Ribble Valley Borough Council
Housing & Development Control

Application no: **3/2024/0067**

Address: **56 St Marys Gardens Mellor BB2 7JP**

Proposal: **Proposed demolition of rear conservatory and construction of single-storey garden room to rear; demolition of front porch and construction of new porch, conversion of garage to habitable room and first-floor extension above; creation of new vehicular access to front and addition of permeable paving to front garden to create parking area.**

1/200 SITE PLAN

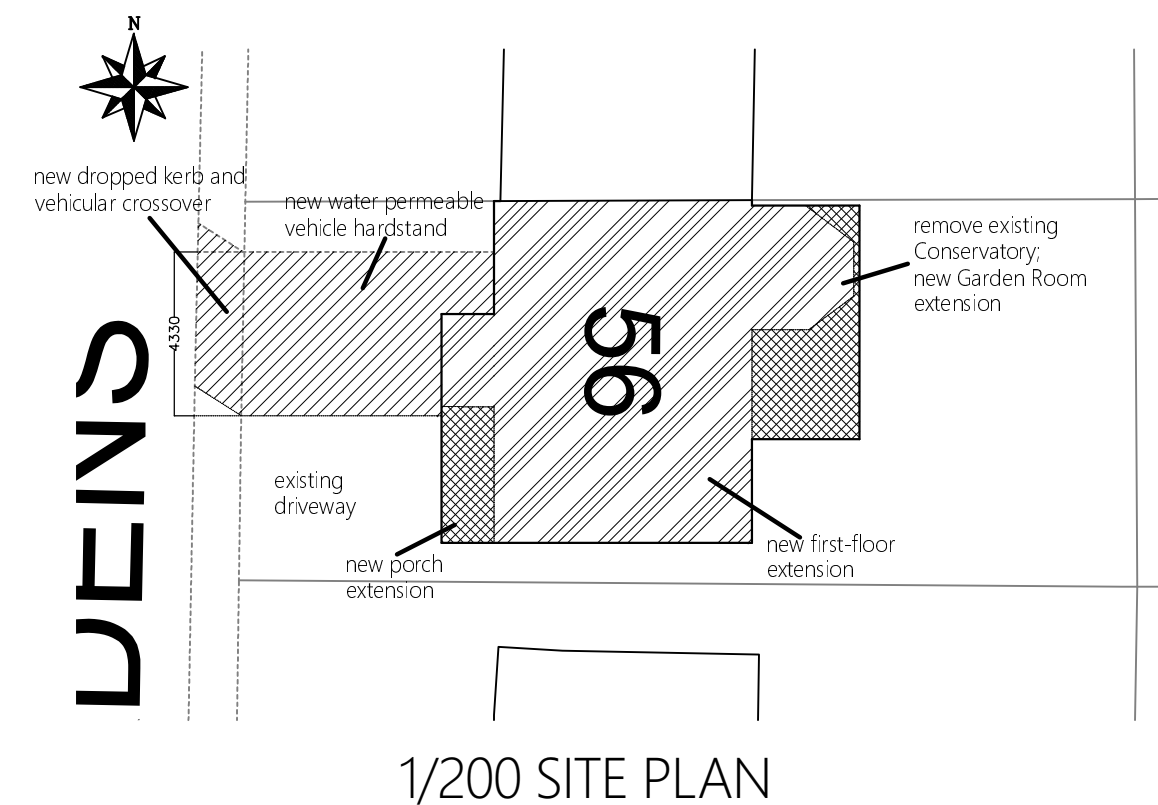
The LHA have reviewed Eaglewood Design drawing number 2023-18-01 Rev B titled "Existing and Proposed Details" and are aware that the existing access will be extended by 4.33m to ensure that a minimum of 2 car parking spaces can be provided on the driveway. This is to ensure that the site can comply with the LHAs parking guidance as defined within the Joint Lancashire Plan following the increase in the number of bedrooms at the site from 2 to 3 and following the conversion of the existing garage.

To provide the extension to the driveway, a dropped kerb application will be required. Please see the informative below for more details.

1.No building or use hereby permitted shall be occupied or use commenced until dropped kerbs have been installed at the carriageway edge and a vehicle cross-over constructed across the footway fronting the site in accordance with the approved plans and Lancashire County Council's Specification for Construction of Estate Roads, to be retained in that form thereafter for the lifetime of the development.

2.The proposed development should not be brought into use unless and until the parking area shown on the approved plans has been constructed, laid out and surfaced in bound porous materials. The parking area shall thereafter always remain available for the parking of domestic vehicles associated with the dwelling.

3.The surface water from the approved driveway/hardstanding shall be collected within the site and drained to a suitable internal outfall.
